**Campbell's Stores
Design Response**

Report prepared for Tallawoladah

This Design Response is submitted to the NSW Government Department of Planning to address public submissions to the EIS made during the period of public exhibition.

Drawing Number
EAL-1001

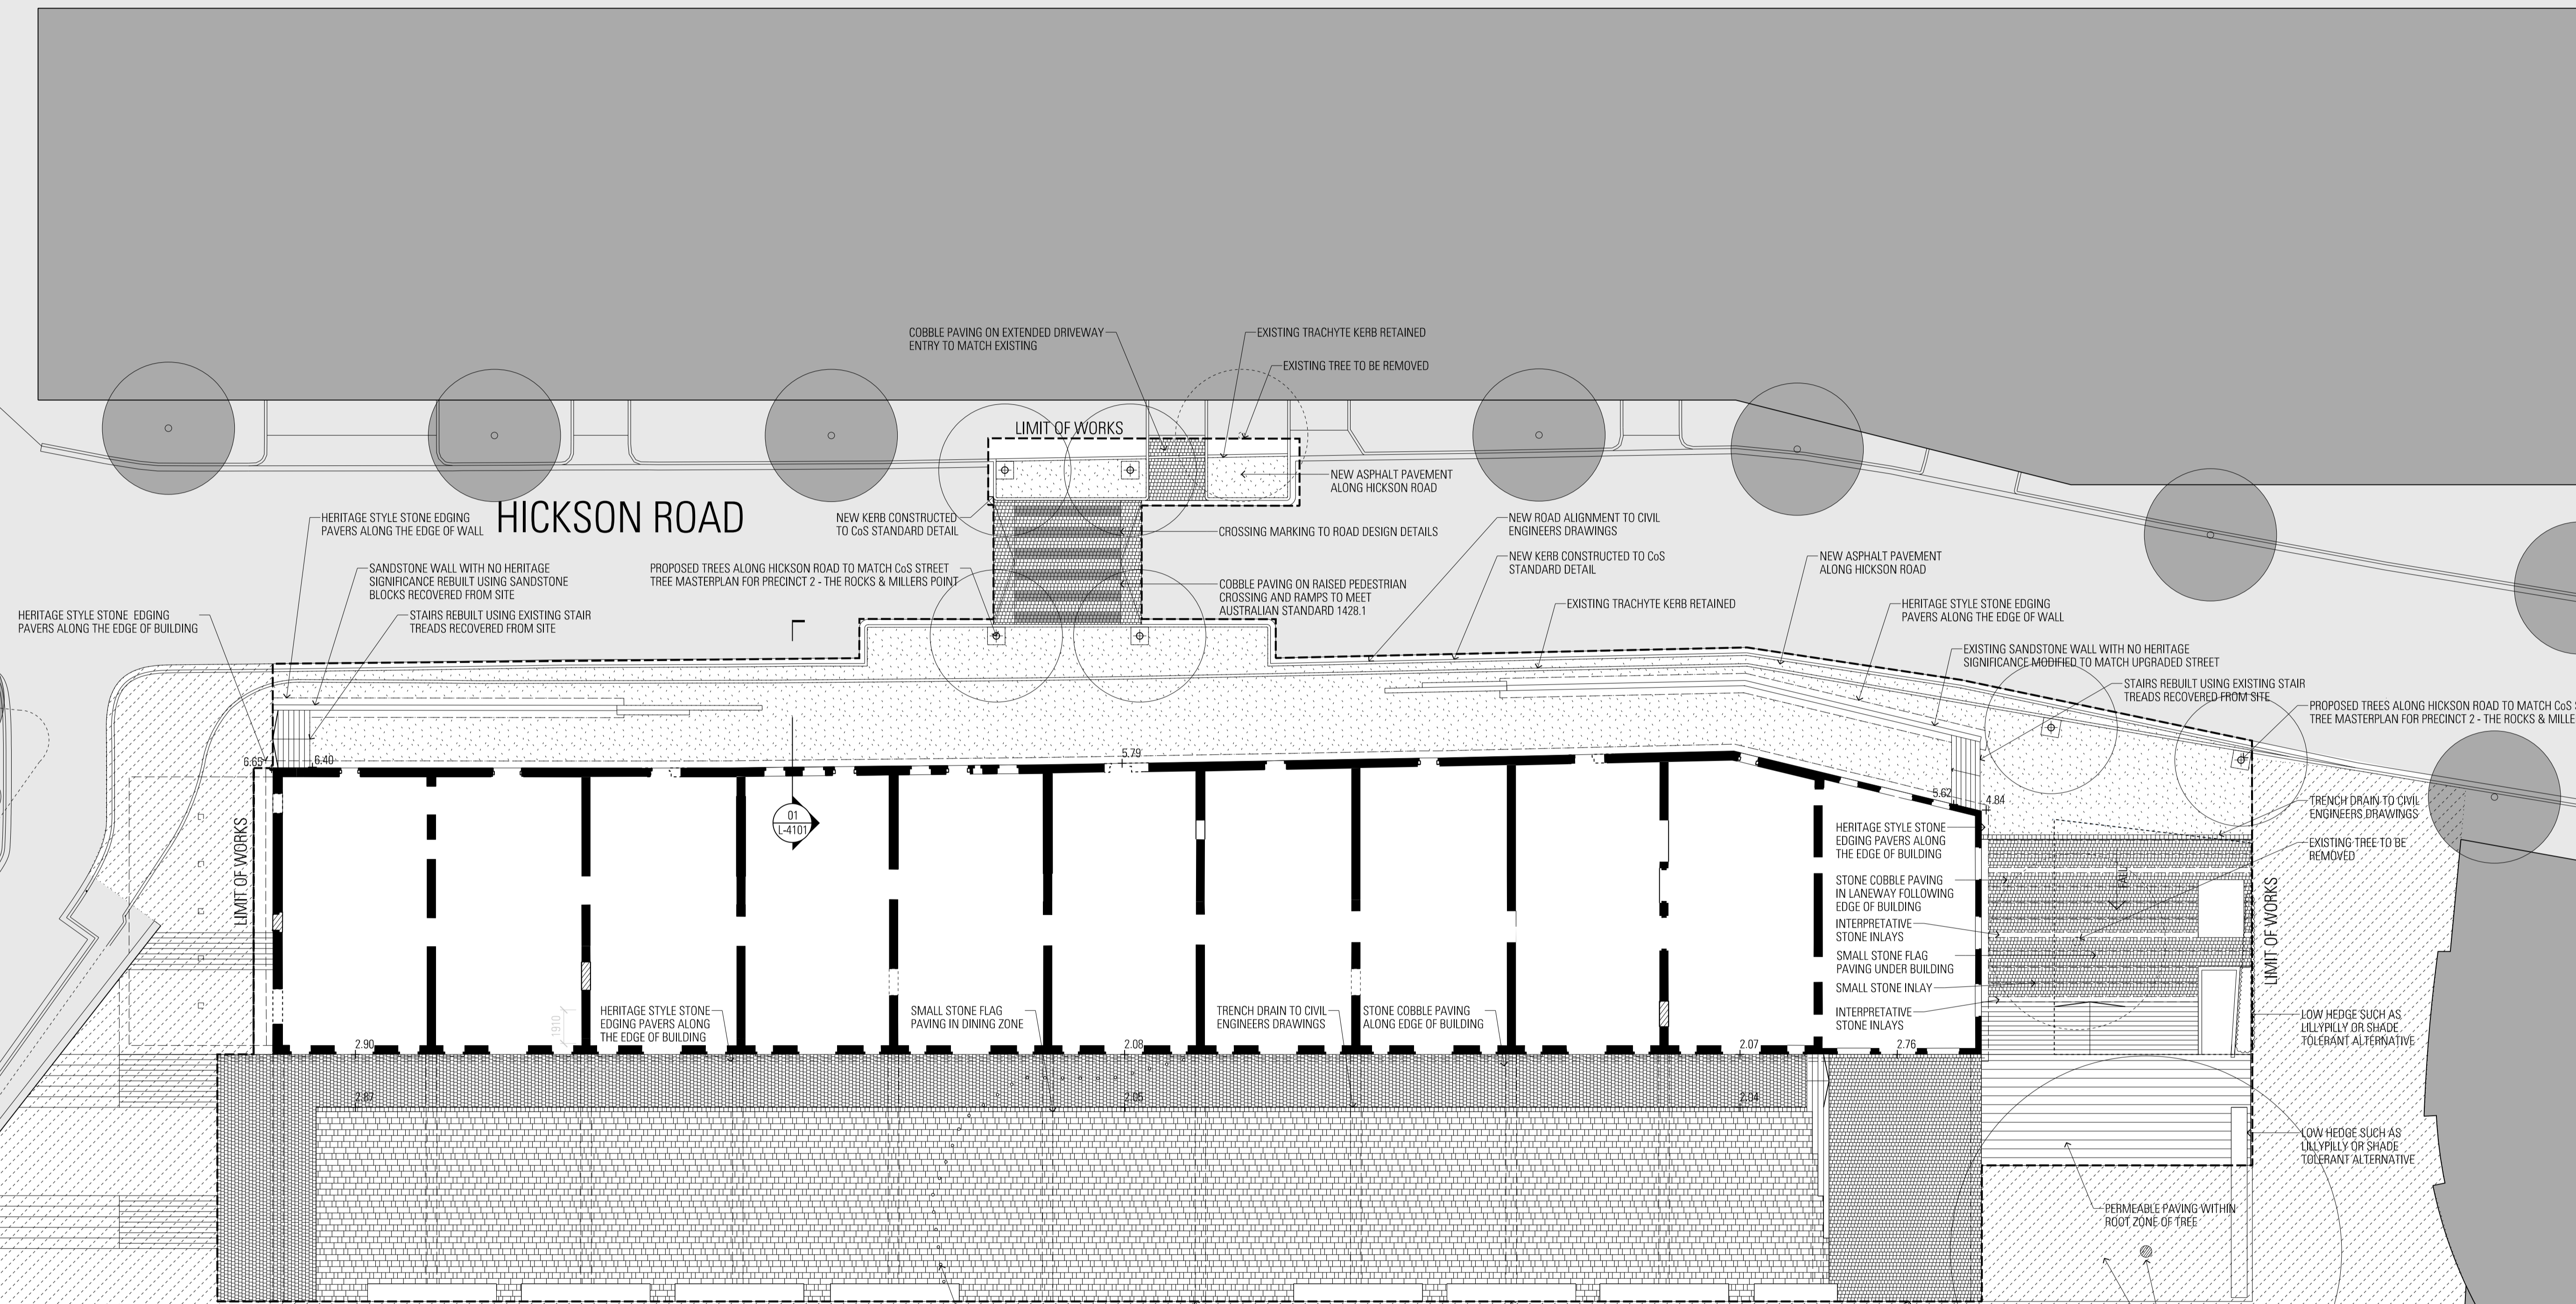
8. Trachyte kerbs are significant to The Rocks area and should be retained and displayed in situ as part of the proposed landscape works.	HC	<ul style="list-style-type: none"> Agreed. The design has been modified accordingly. Refer to Landscape Drawing L-1001 & L-4101

36. Footway widening to the west of the building is supported. However, the existing trachyte stone kerbs should be retained in-situ to reference the original kerb lines, as has been the approach for other roads within The Rocks and Millers Point Village. Notations on the Landscape Plan of "existing trachyte kerb removed and reused on site" are not acceptable to the City. New kerbs should be built to the City's specifications.	CoS	<ul style="list-style-type: none"> Agreed. The design has been modified. Refer above.

JPW agree with the modifications proposed by the Heritage Council and City of Sydney. The design and drawings have been modified accordingly. Additional details and specifications are outlined in the revised Landscape Architecture drawings L-1001 & L-4101, and Figures 2.1 - 2.3.

01 WEST ELEVATION  
SCALE 1:200

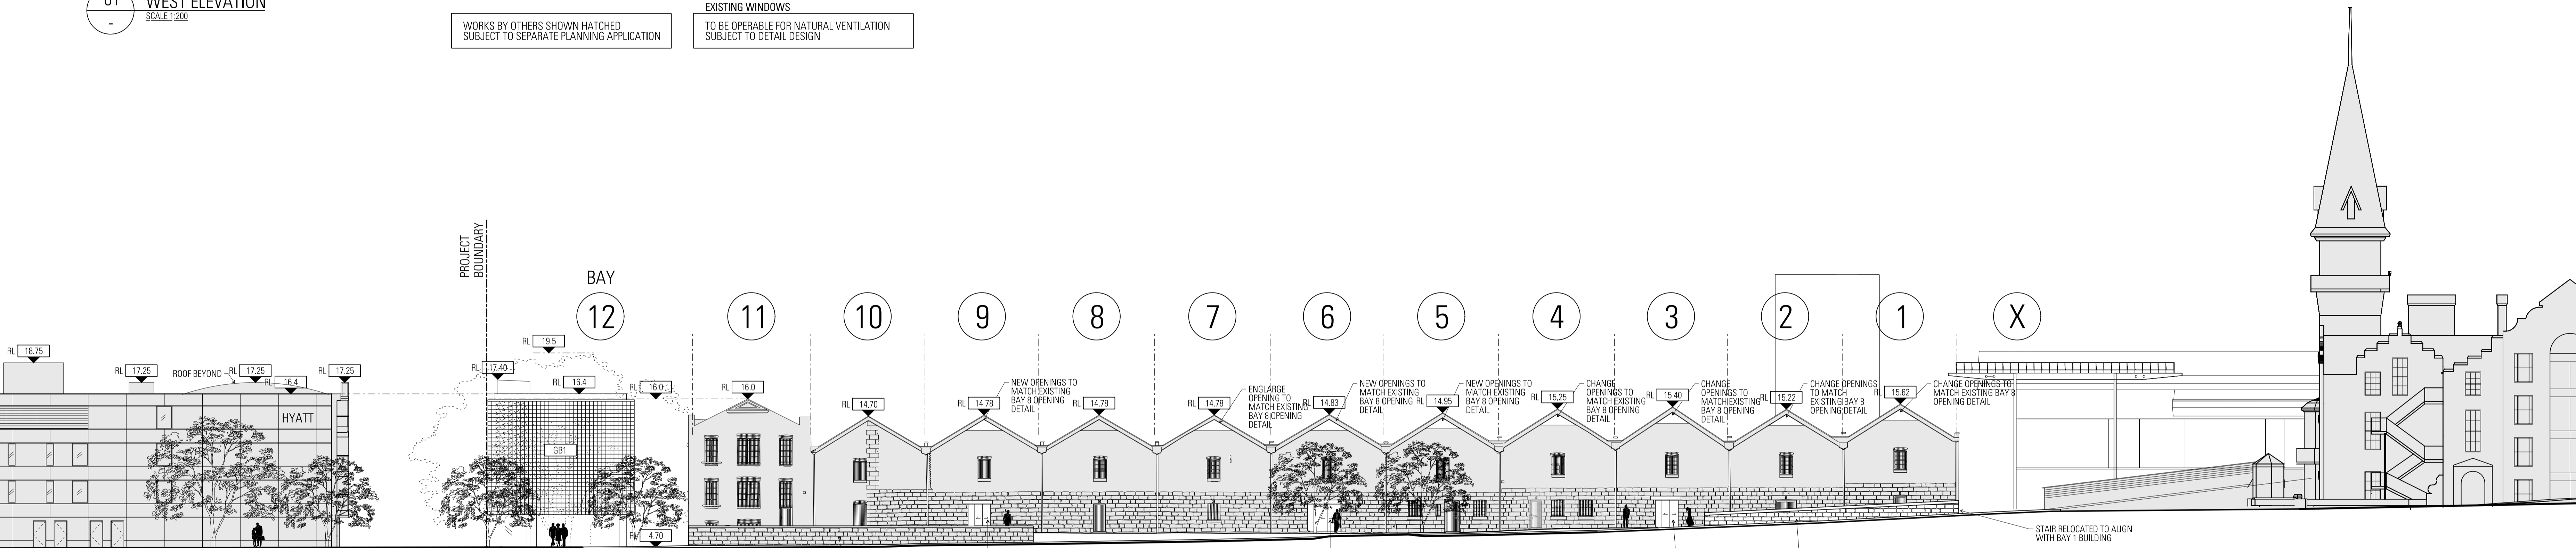
Submission Comments	Agency	Design Response
Design Modifications 6. The new doorways in Bays 3, 6 and 9 of the west facade propose the removal of significant fabric and addition of new contemporary awnings in three locations that would diminish the architectural character of the west facade from Hickson Road to an unacceptable level. It is recommended that approval is granted to Bay 6 only as this is the public bay and would be symmetrically placed.	HC	<ul style="list-style-type: none"> The doorway designs have been refined and reduced in size to specifically respond to the existing heritage conditions of each bay. Refer to summary in Figure 1.1, 1.6 & 1.7 Refer to new, detailed Architectural Drawings A4100-A4103 for detailed demonstration of the design sensitivity to heritage considerations, including retention of significant fabric ✓

- > Retain entrances in Bays 3, 6, & 9
- > Establish a hierarchy of entrances, with Bay 6 as a 'major' through site link entrance, and Bays 3 & 9 as 'minor' entrances (Fig. 1.6)
- > The width of the Bay 3 & 9 entrances to be reduced to 1200mm wide (from 2000mm) this is also the minimum recommended by the Fire Engineer for safe fire egress. (Fig. 1.1)
- > The projection of all of the portals be reduced in depth to 250mm (from 1000mm) to reveal more of the existing heritage elevation to the street. (Fig. 1.1)
